Demolition of the existing Foreshore office & decommissioning of existing underground toilets. New purpose built unisex toilet block including urinals, baby changing facilities & accessible WC, plus a separate beach office with public information point & first aid facilities. All located on the existing seafront promenade.

Promenade Opposite Clarence Road The Esplanade Bognor Regis

Thank you for your internet representation made on 22nd July 2017 which has been recorded as '**an objection**' with the comments as follows:

DRAWING
Proposed Toilet Elevations

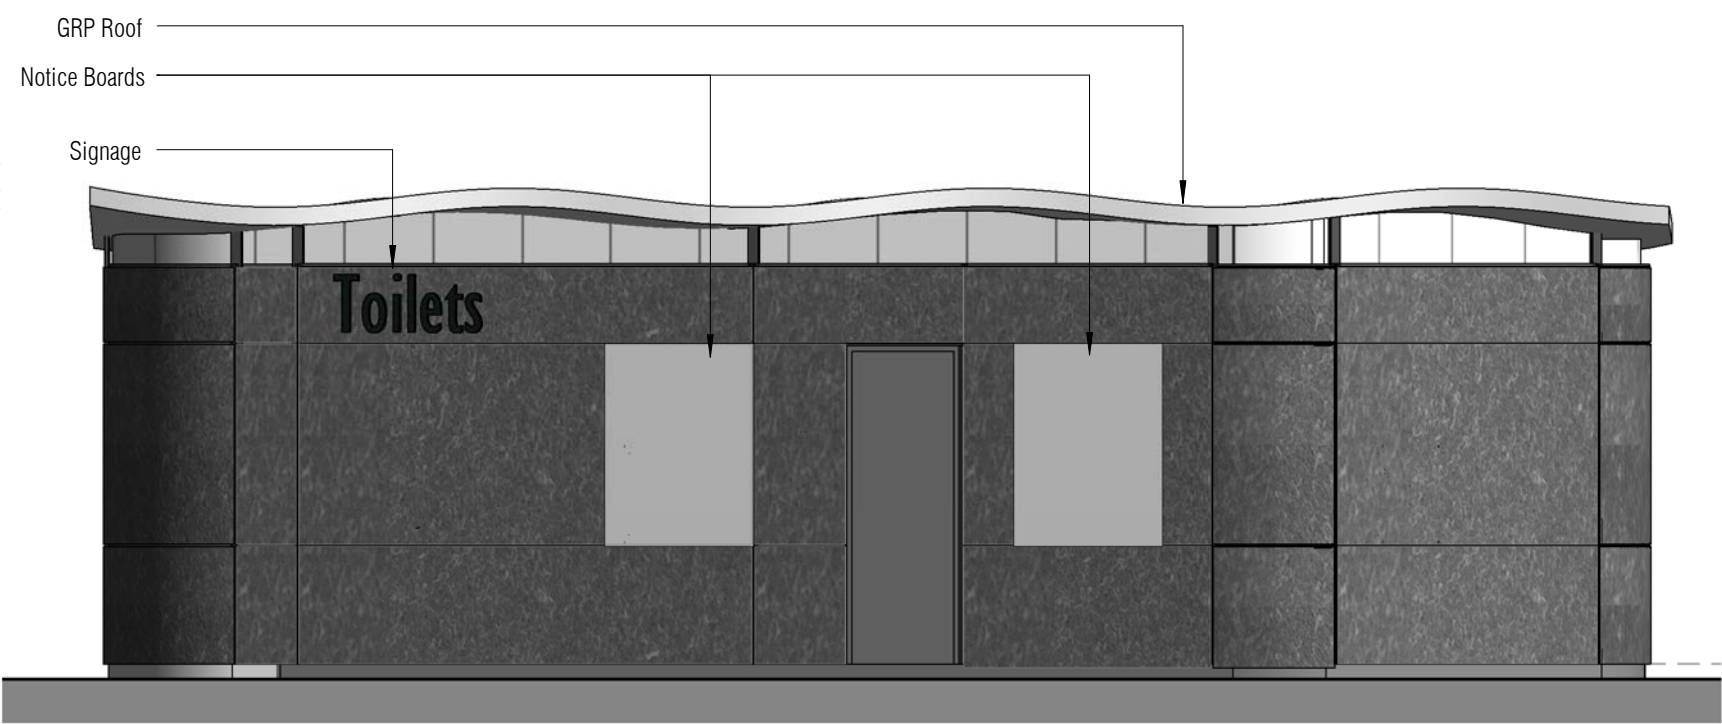
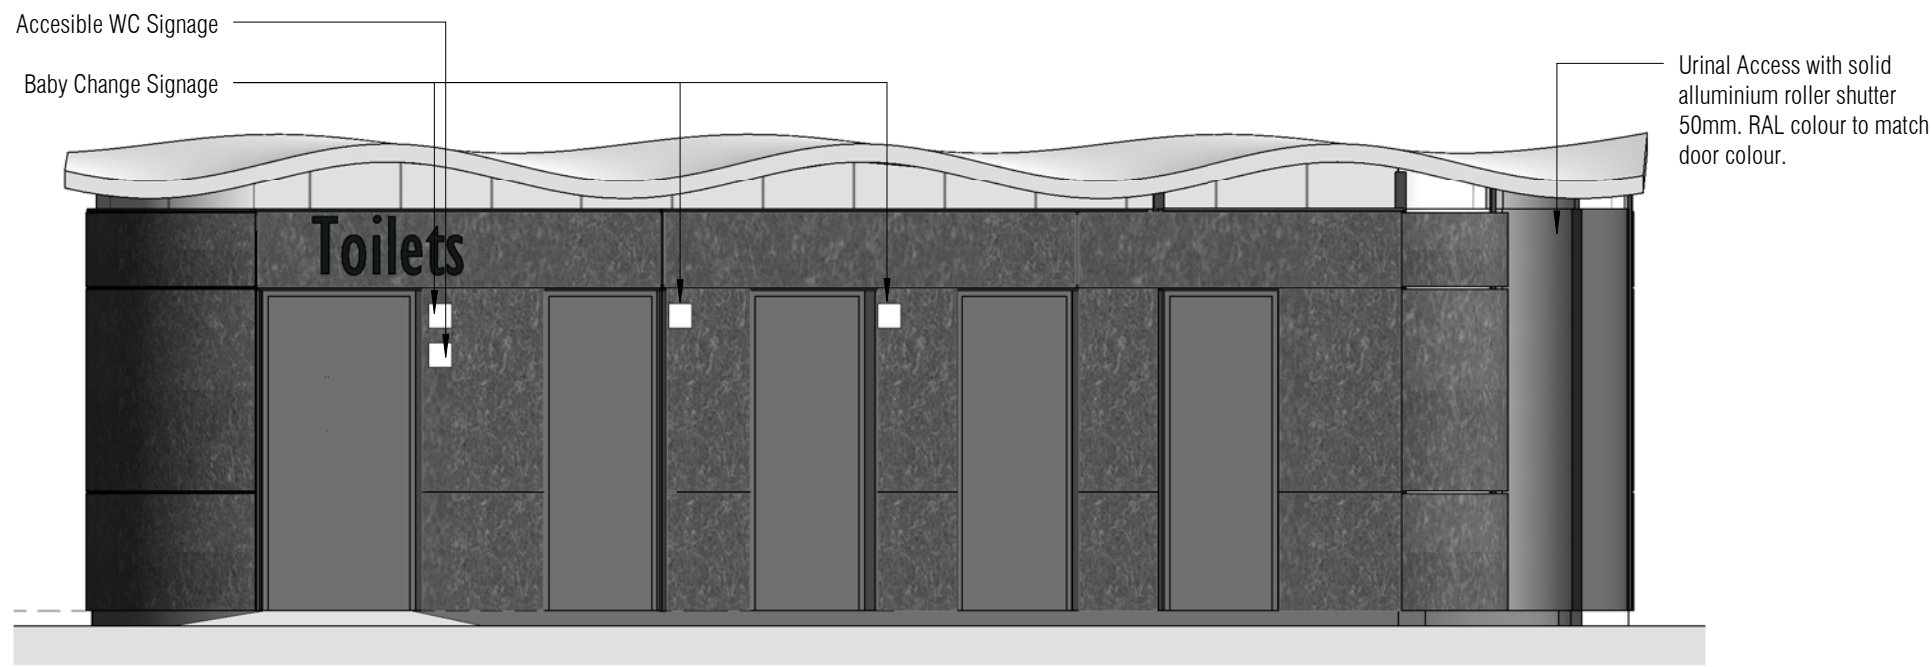
There has been little thought to the aesthetics in this design for a prime site at a seaside resort. Also the doors should be on the south side facing the beach where people will be using them. To have them facing residential properties is an infringement of their right to enjoy their property. To view people entering and exiting toilets and urinals all day long is unacceptable and clearly demonstrates a total lack of regard for local residents. A better design with doors facing south would be a good place to start. As it stands, the temporary structure currently on site is more acceptable.
